Gatwick Airport Northern Runway Project

Statement of Common Ground Between Gatwick Airport Limited and Reigate and Banstead Borough Council

Application Document Ref: 10.1.7

PINS Reference Number: TR020005

Temporary NCR 21 Diversion

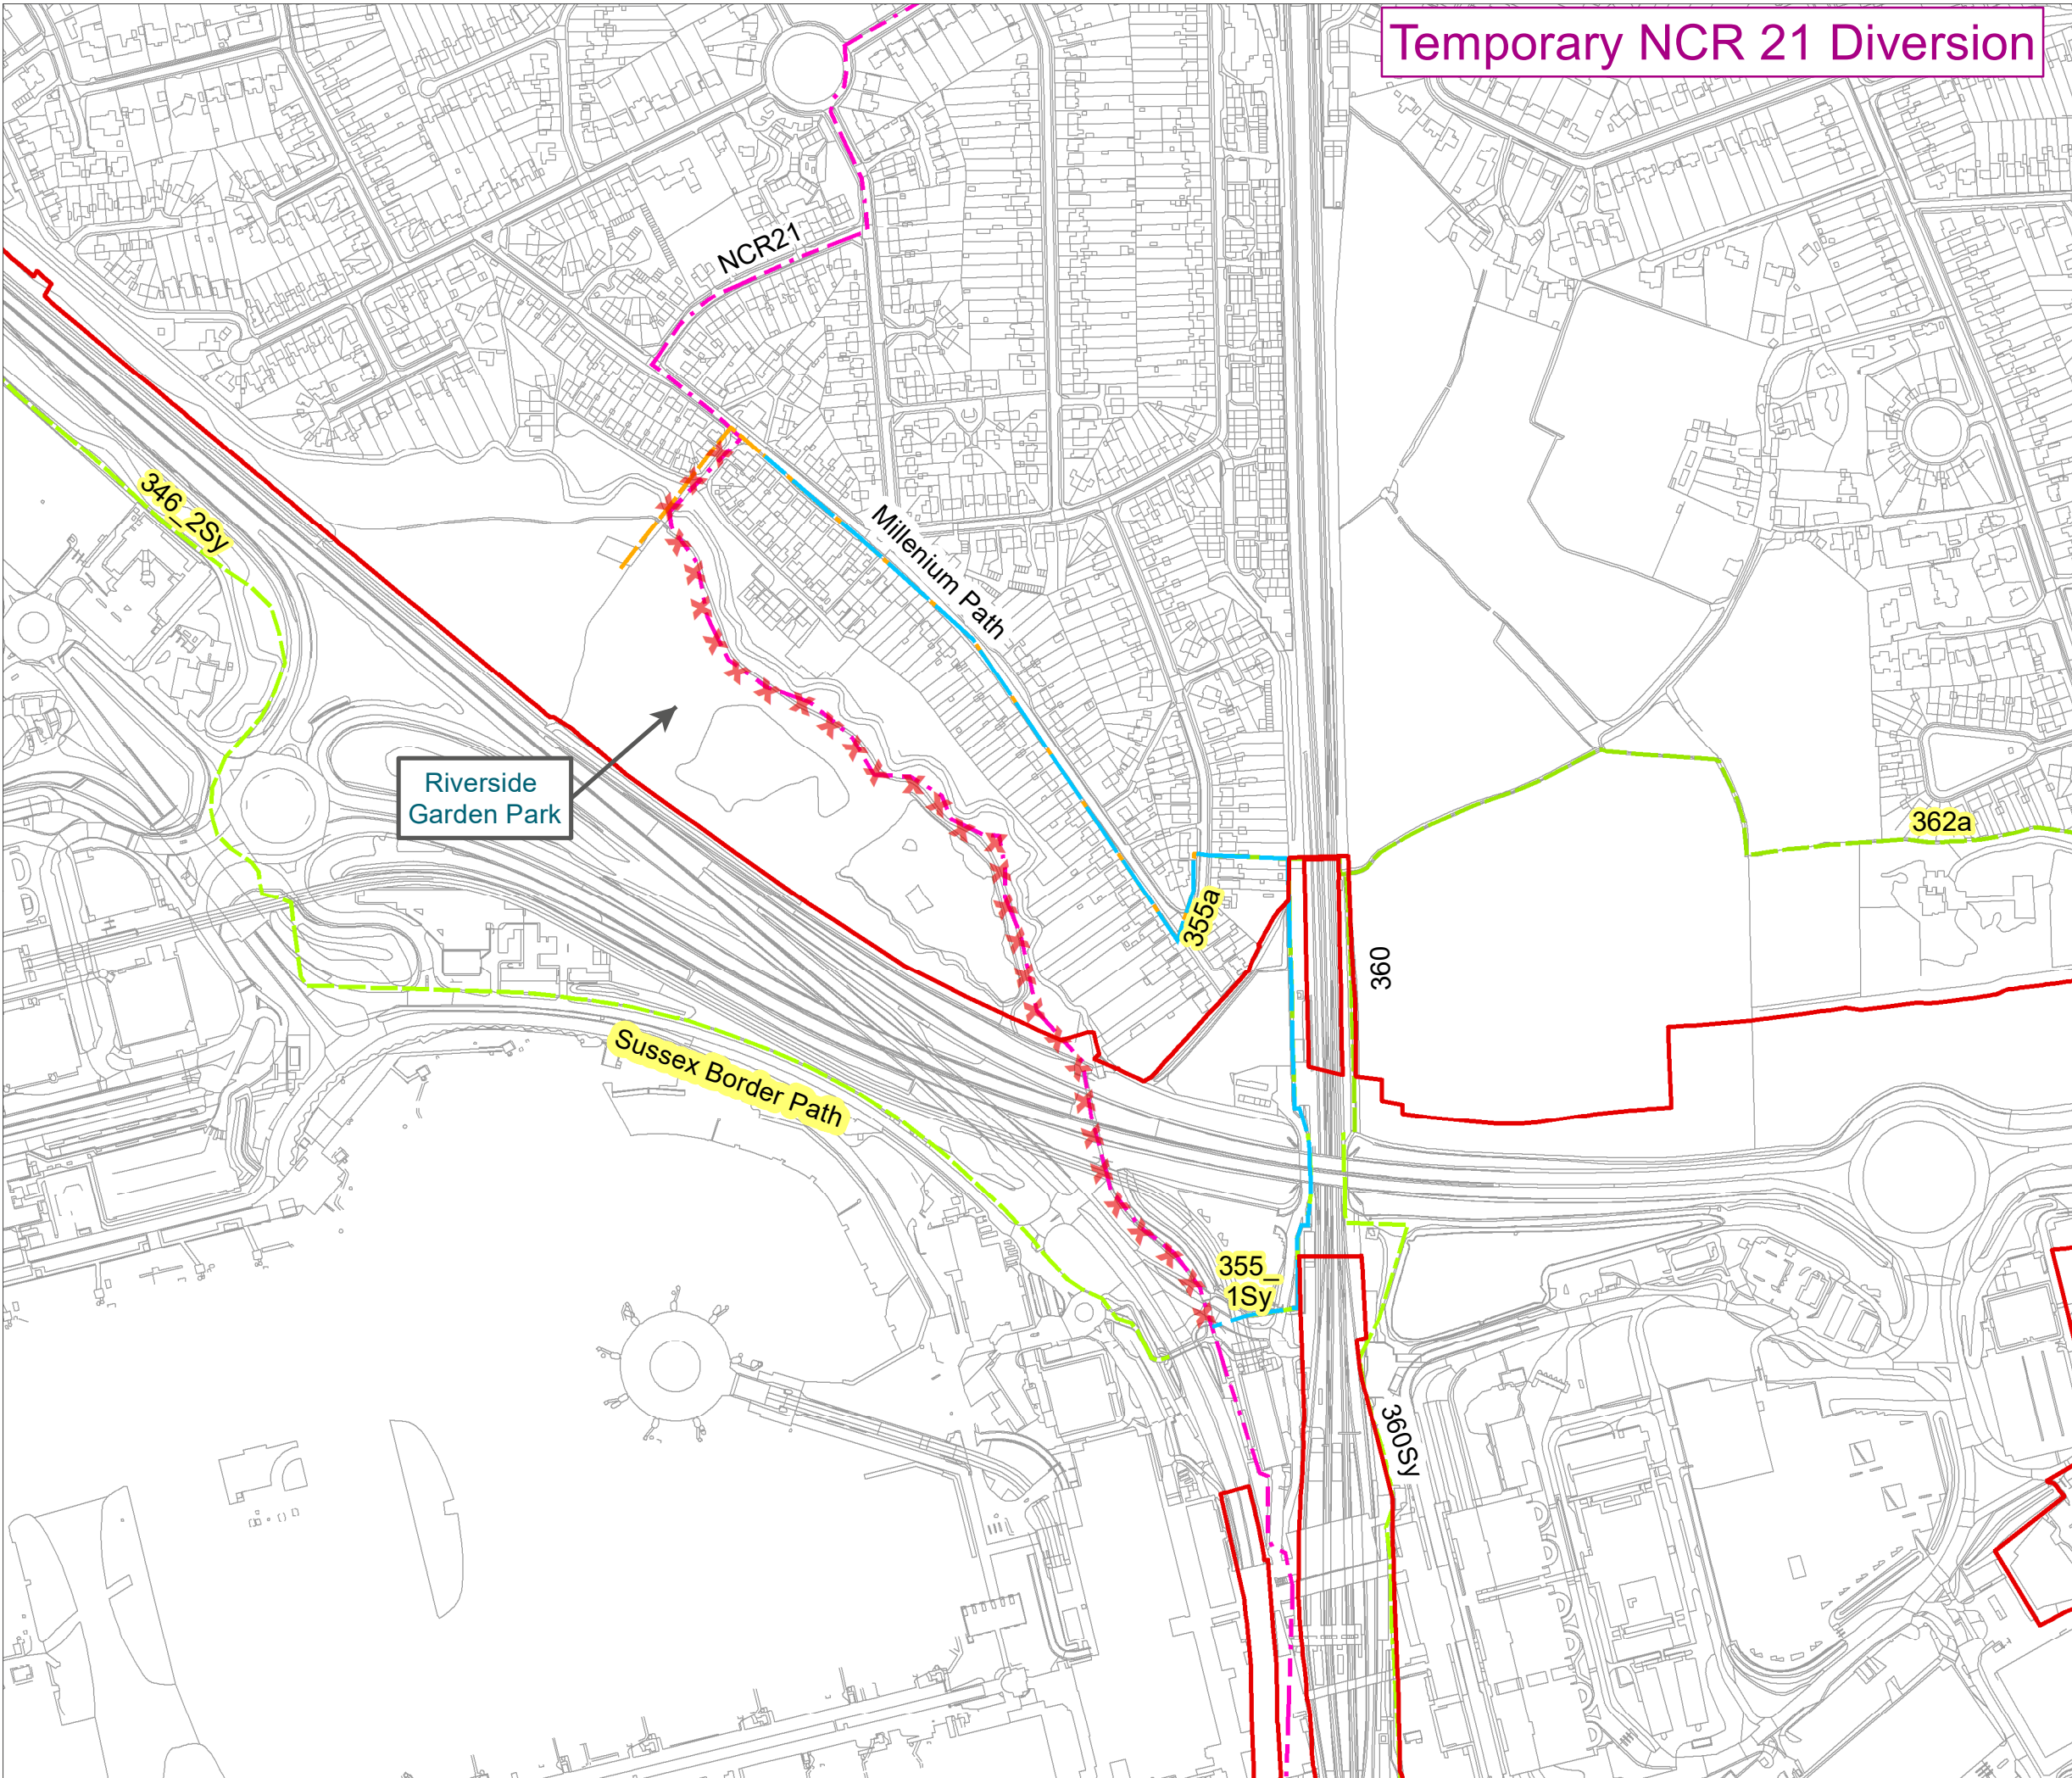
2.1.4.4	Cycle Route NCP21	<p>The route under the A23 will be closed during the road/ bridge works. Alternative north south safe cycle and pedestrian routes must be maintained throughout the closure along with effective communications by the proposer and their contractors. Before re-opening the route should be relayed on the approaches and through the tunnel to encourage more use and an awareness campaign should be run on the reopening, by the proposer.</p> <p>Updated position (Deadline 1): We would welcome the opportunity to participate in reviewing the plan.</p>	<p>This issue has been responded to at Row 1.10 of Table 1 of Appendix 1.</p> <p>Paragraph 19.9.25 of the ES confirms that the temporary closure of West Sussex 355_1Sy/Surrey 355a would not take place at the same time as the temporary closure of NCR 21 to ensure that the connectivity of both NCR 21 and the Sussex Border Path can be maintained during the construction period.</p> <p>The Public Rights of Way Management Strategy states at paragraph 1.1.3 that “detailed PRow implementation plans for</p>	<p>ES Chapter 19 Agricultural Land Use and Recreation [APP-044]</p> <p>ES Appendix 19.8.1: Public Rights of Way Management Strategy [APP-215]</p>	Agreed

<p>individual PRoW would be developed prior to the commencement of construction. Detailed PRoW implementation plans would be in general alignment with the PRoW Management Strategy for the Project and subject to approval by the relevant Local Planning Authority (LPA).”</p> <p>The Local Authority would therefore be consulted on and approve the plan for each implementation plan. secured through DCO requirement 22 in Schedule 2 of the Draft DCO.</p>

- Project Site Boundary
- Footpath 360_1Sy
- Temporary Footpath Route
- ▲ Northern Access
- ▲ Southern Access

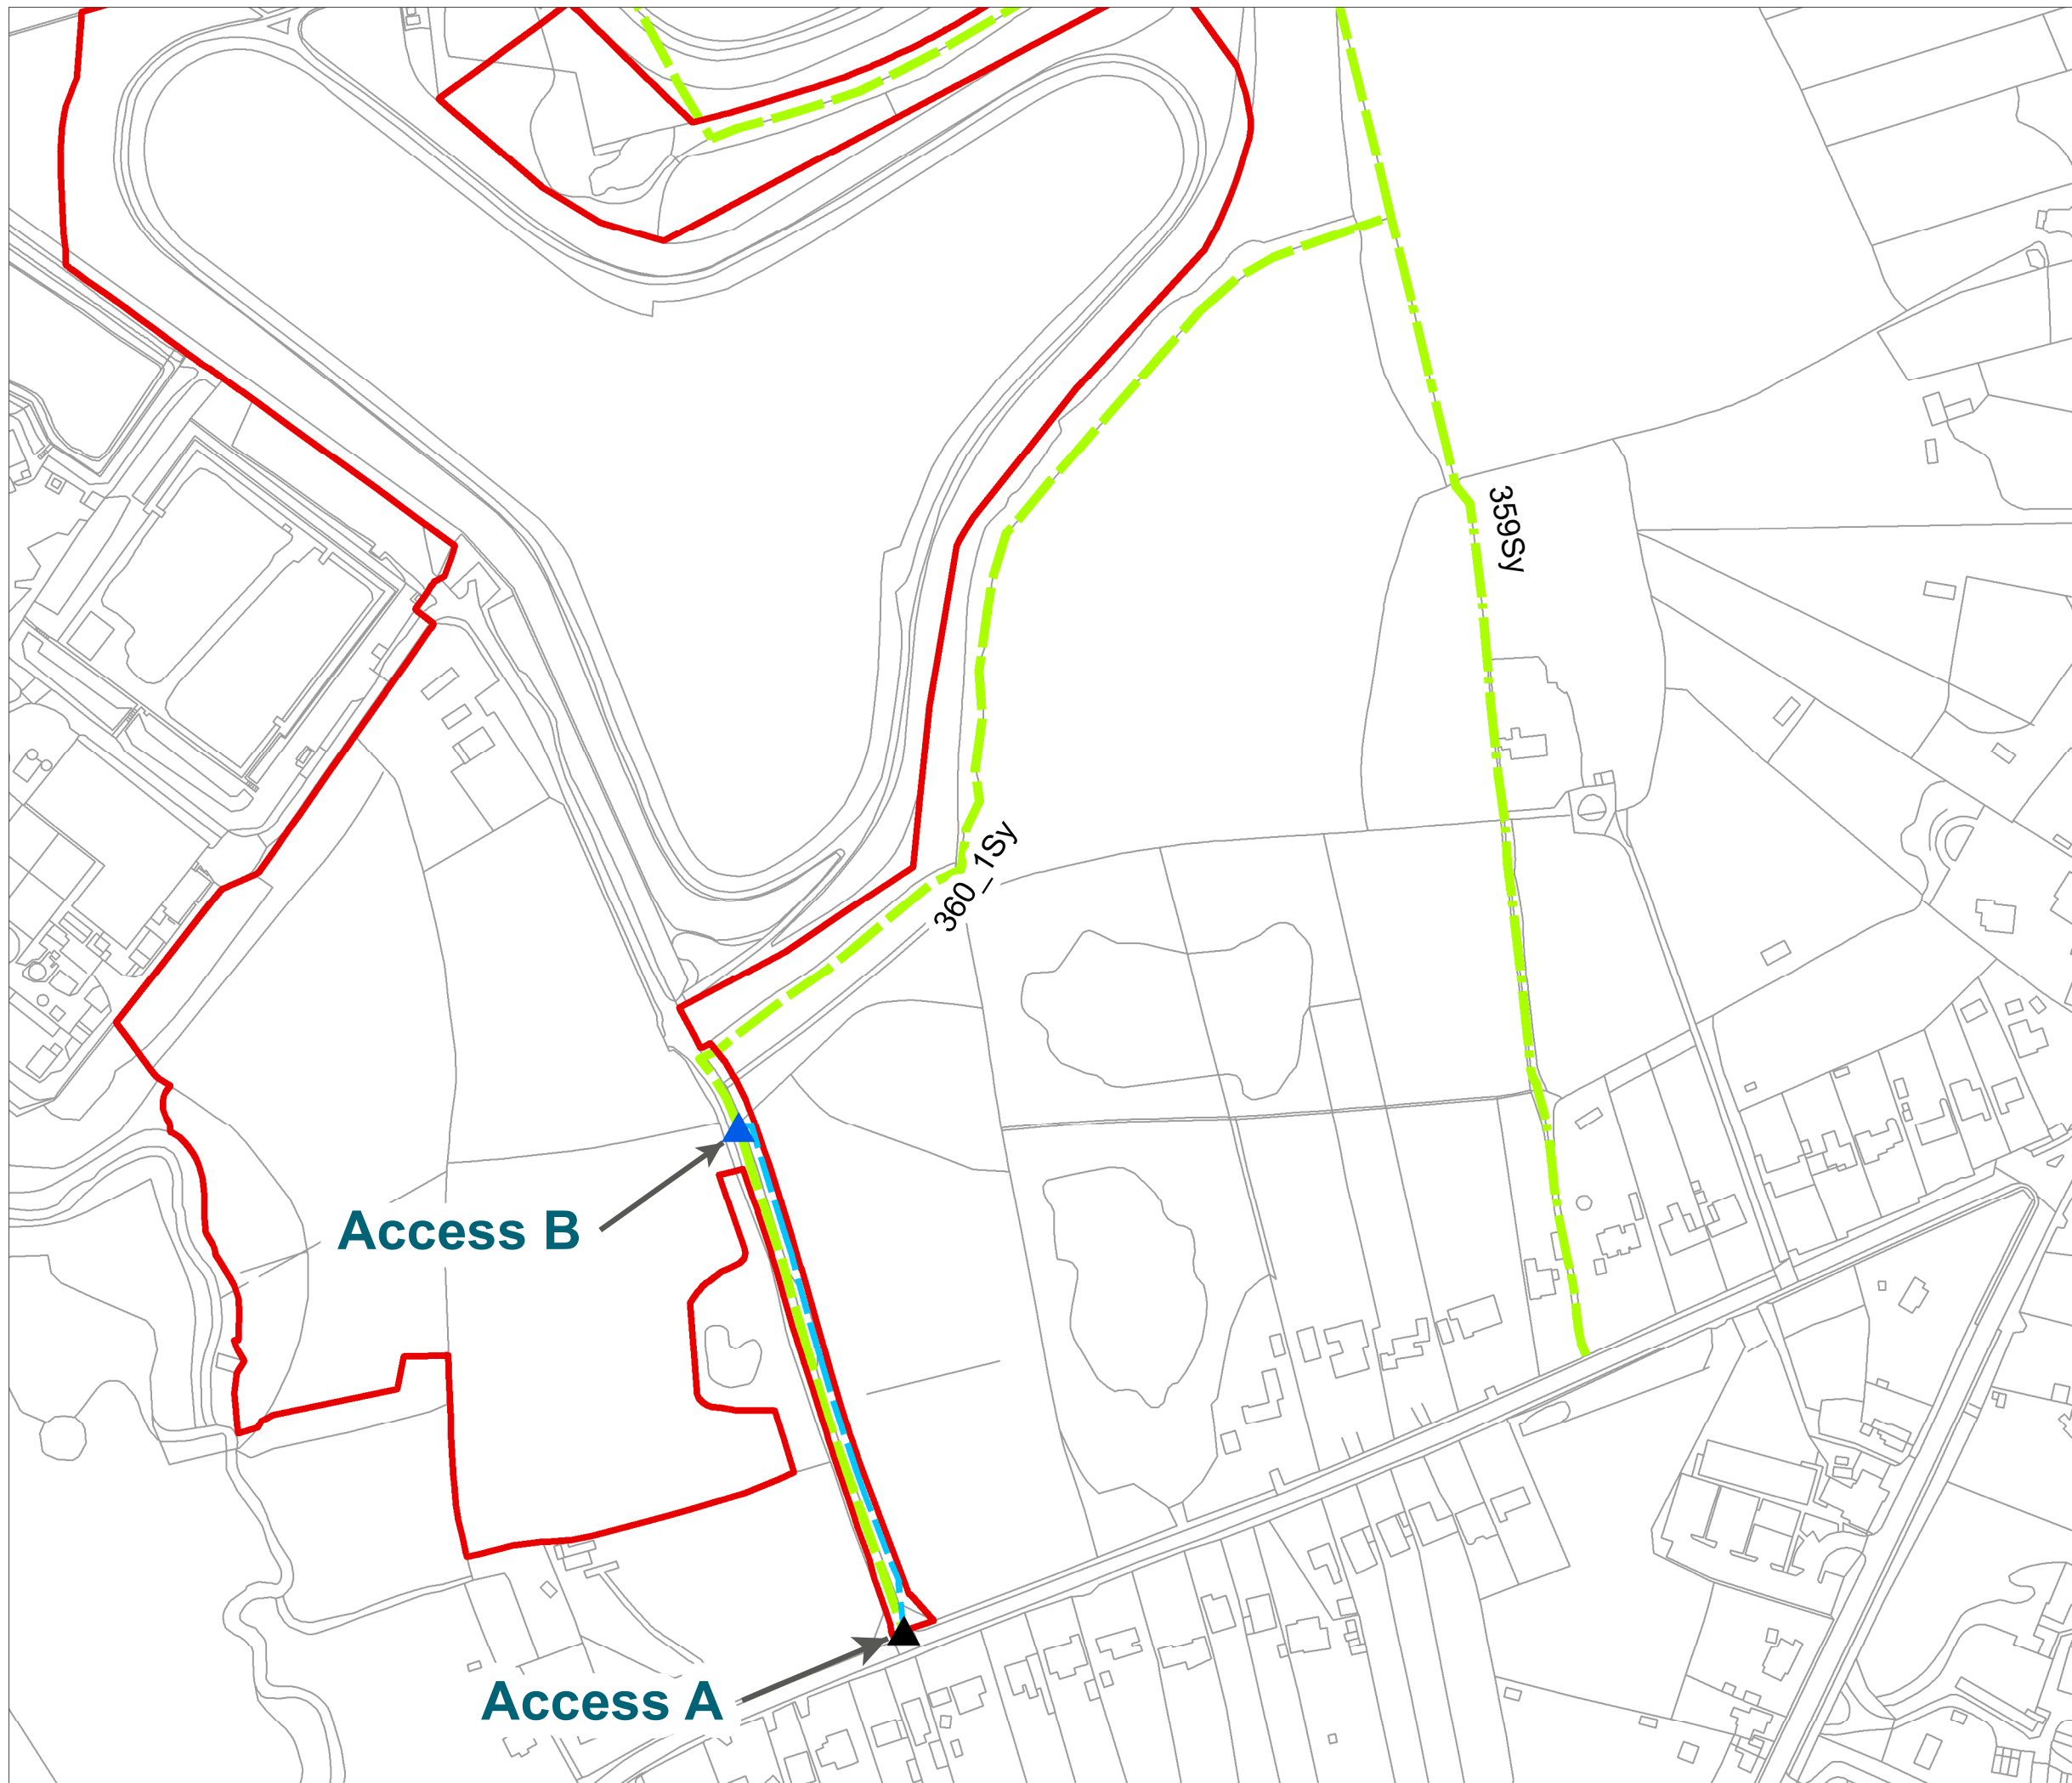
2.1.4.8	London-Brighton Railway/ A23 Bridge works	<p>The closure of the north south footpaths 355a and 360 and footbridge over the London – Brighton railway line to the north of the A23 Brighton Road will impact users of 362a (shown on the Rights of Way and Access Plans [APP-018]). Moreover, Table 4.1.1 of the Public Rights of Way Management Strategy [APP-215] does not include the period when the footpath will be shut, only the duration. It is considered important that one of the north south footpaths including NRP21 remains open during the construction phase to enable Horley workers to access the airport by foot or bicycle without having to take a 25 minute detour to the east or west. On the restoration of the footpaths after the works paragraph 4.1.1 refers to surfaces being restored to “a suitable condition”. However, this is too vague, and all footpath restorations should be agreed with the appropriate local authority to ensure the footpath is useable following the works. We also note that the footbridge to the north of the main railway line A23 bridge works is included in the dDCO but it is unclear how this will be used as an access point for works related use. This is of concern as the alley way passes between residential properties in The Crescent and multiple works associated vehicles parking in The Crescent would cause issues for local residents.</p> <p>Updated position (Deadline 1): RBBC would welcome the opportunity to assess the PRow implementation plans.</p>	<p>The footbridge over the London to Brighton railway line to the north of the A23 is not proposed to be closed during the construction period.</p> <p>Table 4.1.1 of the Public Rights of Way Strategy does provide the construction works where the diversion would be required and the approximate duration of these works, based on the preliminary highway design.</p> <p>The Public Rights of Way Management Strategy states at paragraph 1.1.3 that “detailed PRow implementation plans for individual PRow would be developed prior to the commencement of construction. Detailed PRow implementation plans would be in general alignment with the PRow Management Strategy for the Project and subject to approval by the relevant Local Planning Authority (LPA).”</p> <p>The Local Authority would therefore be consulted on and approve the plan for each implementation plan.</p>	<p>ES Chapter 19 Agricultural Land Use and Recreation [APP-044]</p> <p>ES Appendix 19.8.1: Public Rights of Way Management Strategy [APP-215]</p>	Agreed

2.1.5.4	Railway Line Footbridge north of A23 Bridge works	<p>Concern that the alleyway from The Crescent and footbridge will be used as point of access during A23 Railway Line bridge widening works.</p>	<p>ES Appendix 5.3.2, CoCP Annex 3 - Outline Construction Traffic Management Plan, Section 6.4, outlines the use of local roads during construction works.</p>	ES Appendix 5.3.2 Code of Construction Practice – Annex 3	Under discussion

<p>Updated position (Deadline 1): Welcome preparation of CTMP though we would still like to review the document before this can be agreed. We welcome the aims of the plan in terms of minimizing impacts to residents and the rental scheme.</p>	<p>Gatwick Airport Limited (GAL) and its contractors will prepare a detailed Construction Traffic Management Plan (CTMP) that will specify measures to effectively manage construction-related traffic disruptions. This plan aims to minimize the impact on residents, road users, and airport operations. Additionally, agreements through local authority land rental schemes will be established before the commencement of construction.</p>	<p>– Outline Construction Traffic Management Plan [APP-085]</p>
